**KIRKLEES METROPOLITAN COUNCIL
INVESTMENT & REGENERATION SERVICE**

DELEGATED DECISION TO DETERMINE PLANNING APPLICATIONS

Reference No:	2024/62/90365/W
Site Address:	13, Benomley Crescent, Almondbury, Huddersfield, HD5 8LT
Description:	Erection of two storey side extension
Recommending Officer:	Molly Storer

HOUSEHOLDER DELEGATED REPORT –

client	RYAN CARTER AND LEAH WORSLEY		
project	PROPOSED EXTENSION TO 13 BENOMLEY CRESCENT ALMONDBURY HUDDERSFIELD, HD5 8LT		
drawing	PROPOSED PLANS		
revision	notes	date	drawn
*	*	*	*
scale :	1:50 AND 1:100 AT A1	06.23	PB
project no.	2283	drawing no.	02

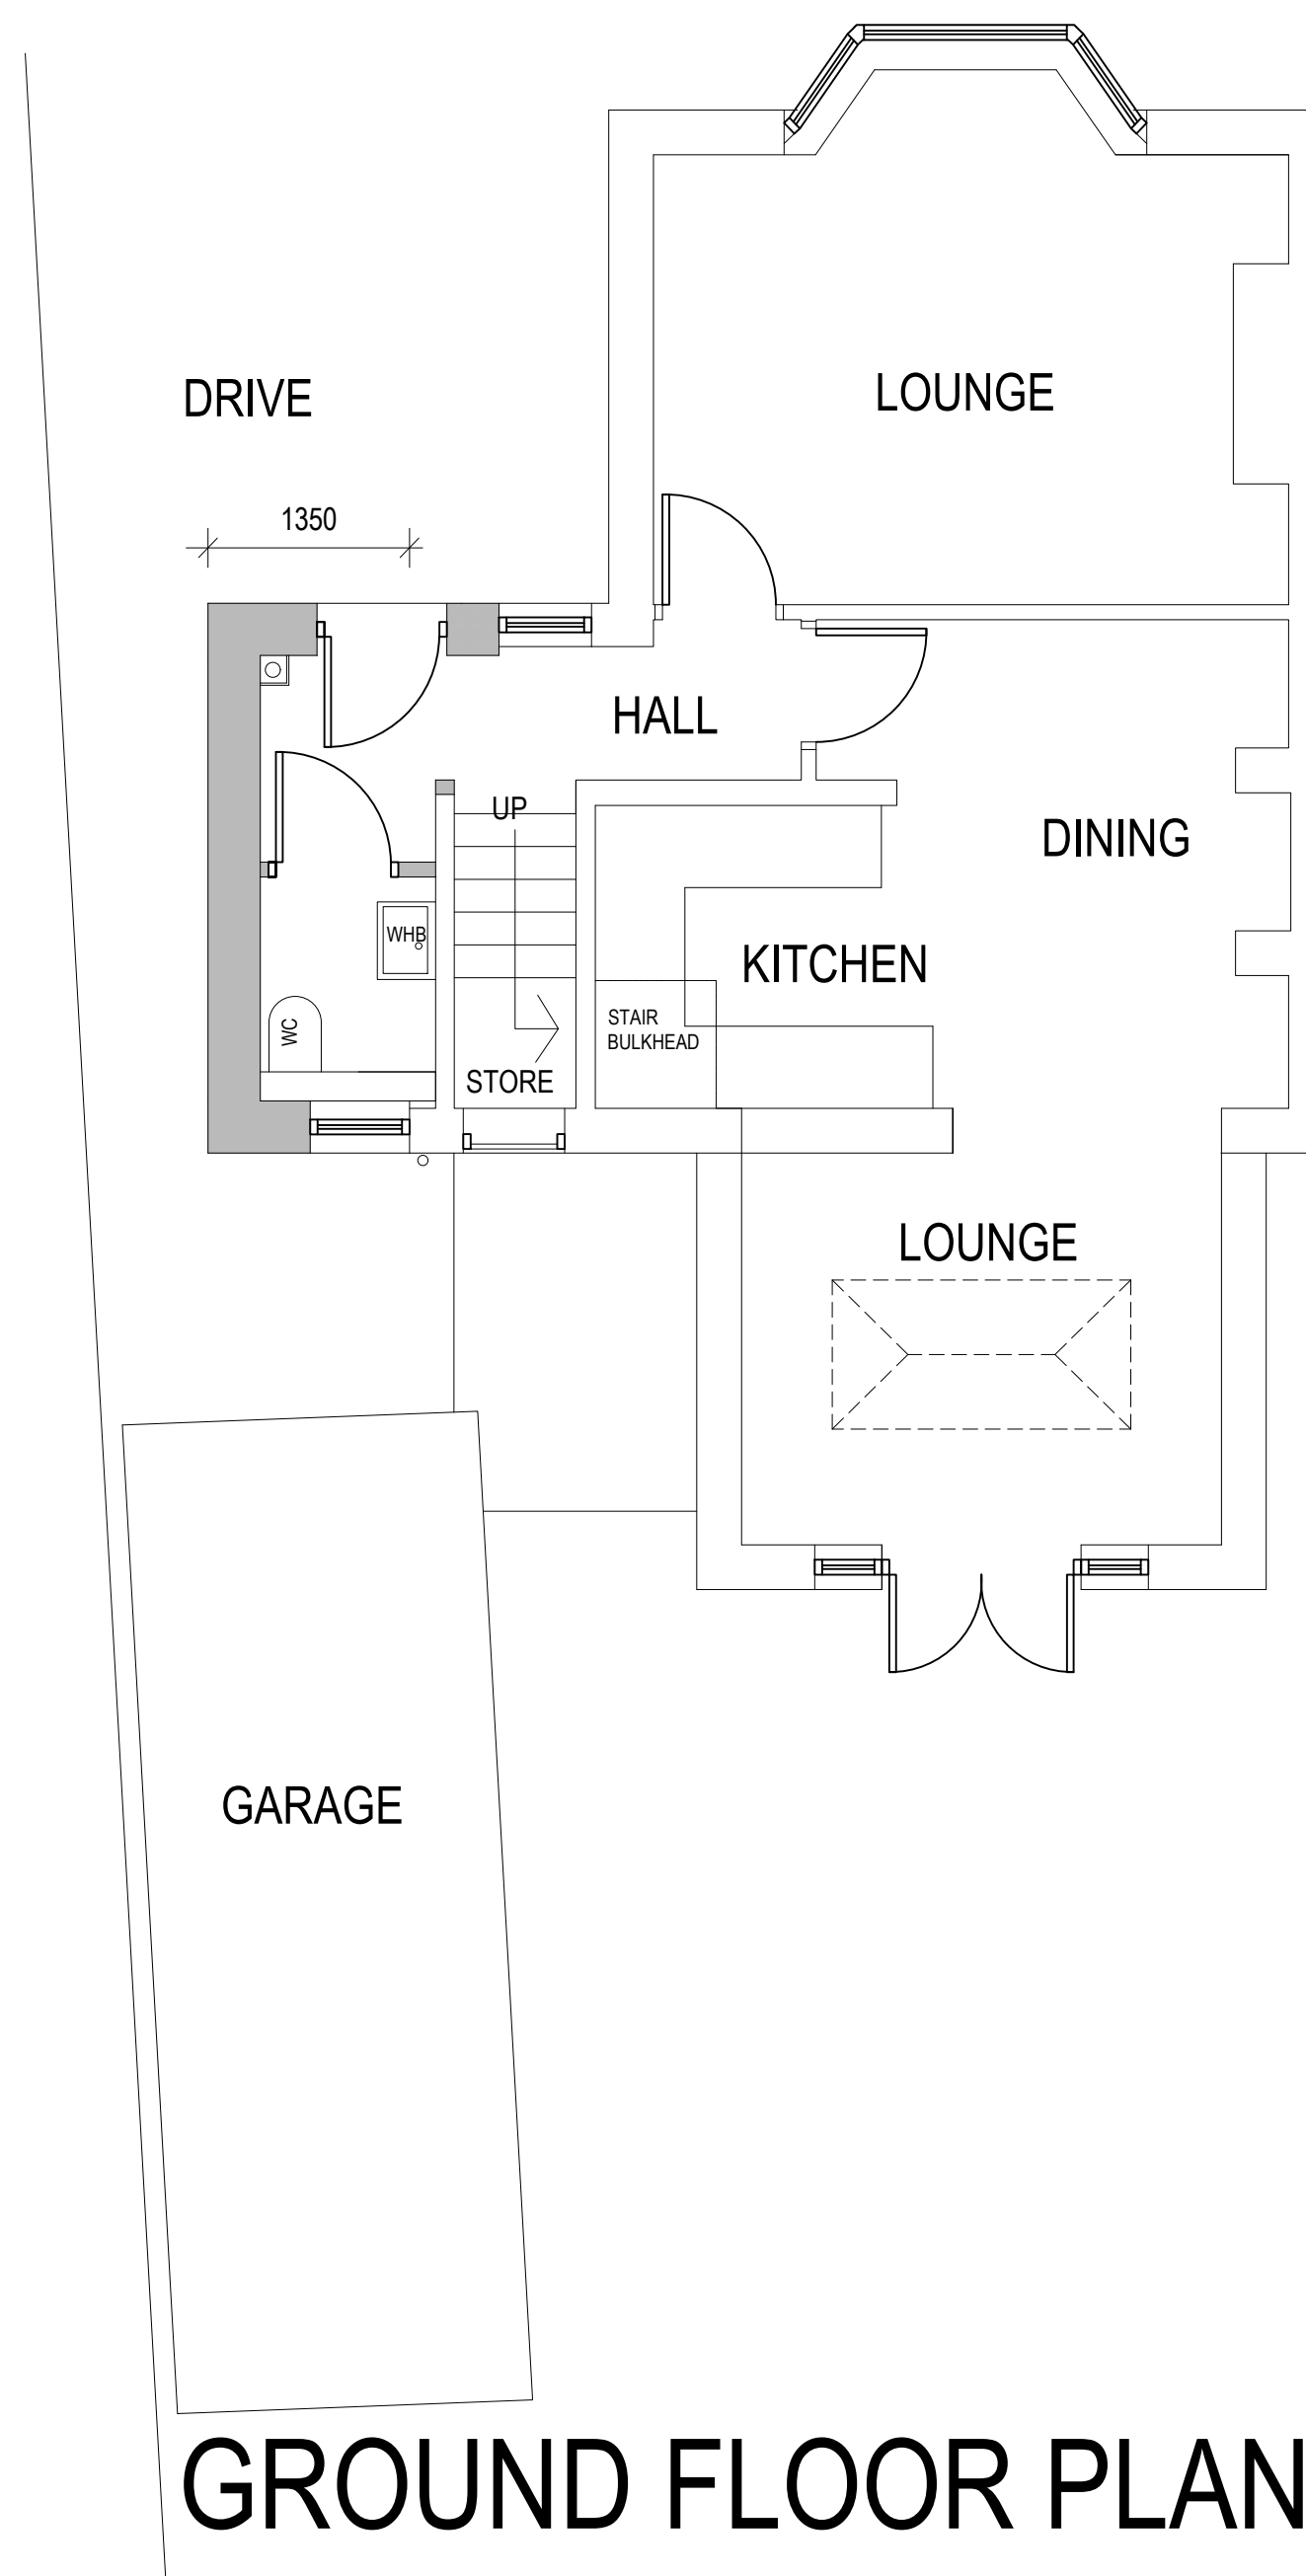
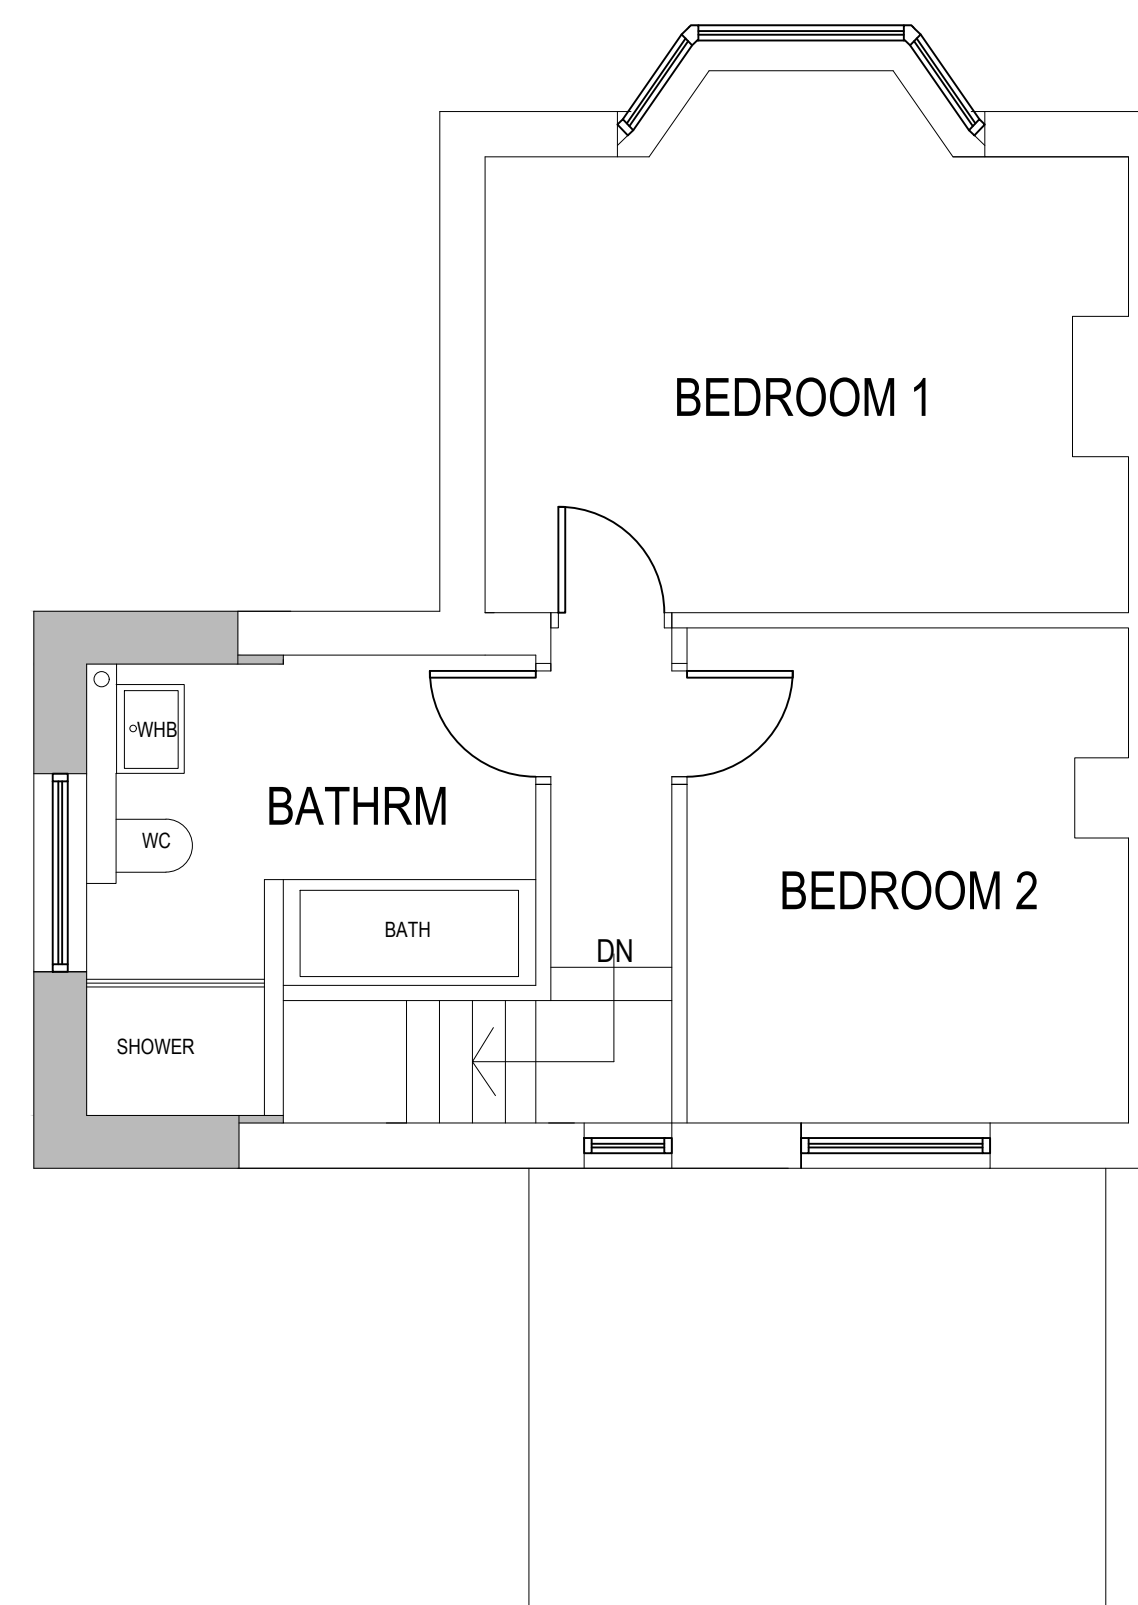
The application seeks permission for a two storey side extension. The proposed two storey extension would be located on the west side elevation of the property. The original dwelling has a section which already projects beyond this elevation by 0.6m, the extension will project to the side of this. The extension will be set back from the front elevation of the property by ~3.3 meters and would project to the side by 1.6 meters with a width of 3.6m. The extension would lie flush with the original rear elevation of the dwelling. The eaves height would match the existing with hipped roof line being set down from the existing main roof ridge by 1.88m.

Two storey side extensions should:		
Not take up all or most of the space to the side of a house	Yes – the extension is set in from the side boundary of the property	
maintain a 1 metre gap to the side boundary to ensure the building is not too close to a neighbouring property		No – a 1 metre gap is not retained between the side boundary and the extension, however is set in by ~0.8 metres and the neighbouring property set in from the shared boundary by approx. 2.75 metres ensuring a sense of space is retained between the dwellings
be set back at least 500mm from the front wall of the house	Yes – the extension is set back from the front elevation of the property by more than 500mm

Impact on the Local character and street scene	• KDP1 of the SPD • Policy LP24 Design (a) and (c) of the KLP • Chapter 12 NPPF	Other side extensions within the street scene – extension is set back from the front elevation with the roof line set down and therefore no established front and rear building lines are obstructed. No terracing effect would occur should adjacent neighbour also extend to the side	✓
Impact on original house	• KDP2 of the SPD • Policy LP24 Design (c) and (d) of the KLP • Chapter 12 of the NPPF	Set back from front elevation, roof line set down from existing. The extension will have a limited projection and width therefore the structure appears subservient.	✓
Height, scale and massing	• KDP 1 and 2 of the SPD • Policy LP24 Design (a), (c) and (d) of the KLP • Chapter 12 of the NPPF	Subservient due to its limited massing and set down height.	✓
Facing materials and detailing	• KDP 9 of the SPD • Policy LP24 Design (d) (iii) of the KLP • Chapter 12 of the NPPF	The walls will be constructed from brick and render with the roof being constructed from blue slate. These would match the existing and be conditioned as part of the decision notice	✓

Roof style	• KDP 1 and 2 of the SPD • Policy LP24 Design (a), (c) and (d) of the KLP • Chapter 12 of the NPPF	Hipped to match the existing	✓
Window proportions	• KDP 1 and 2 of the SPD • Policy LP24 Design (a), (c)	Single opening in the rear elevation would be, proportionate in terms of size and scale with the existing. The opening	✓

and (d) of the KLP Chapter 12 of the NPPF	within the side elevation would replace a similar window that is already positioned in this elevation.	
Accessibility for all users	- KDP 17 of the SPD - Policy LP24 Design (f) - Chapter 12 of the NPPF	Main entrance to the property would be retained as existing	✓

Relevant key design principle (KDP) of the SPD, Policy in the Kirklees Local Plan and the NPPF	Further comments	✓ / X / N/A
Impact on privacy of neighbours (to sides, rear and front)	- KDP 3 & 4 of the SPD - Policy LP24 Design (d) (iv)	Limited impact due to a single window being located in the side elevation which will host a bathroom and will be obscurely glazed. The	✓

Chapter 12 of the NPPF	only window that this will face No.15's obscurely glazed bathroom window.	
Impact on light and outlook of neighbours (to sides, rear and front)	- KDP 4, 5, 6 of the SPD - Policy LP24 Design (b) - Chapter 12 of the NPPF	Due to siting and orientation, it is likely that some element of overshadowing already occurs to opening within side elevation of No. 15 during the early hours of the summer months. As the openings appear non-habitable and serve a bathroom, it is not considered that any further harm would be significant.	✓
Impact on overbearing or overshadowing	- KDP 5, 6 of the SPD - Policy LP24 Design (b) - Chapter 12 of the NPPF	No significant impact due to the structure being within the confines of the side elevation of the dwelling and having a limited projection and width.	✓
Remaining garden space of application property	- KDP 7 of the SPD - Policy LP24 Design (b) and (c) - Chapter 12 of the NPPF	An adequate amount of garden amenity space would be retained to the front and rear of the property.	✓
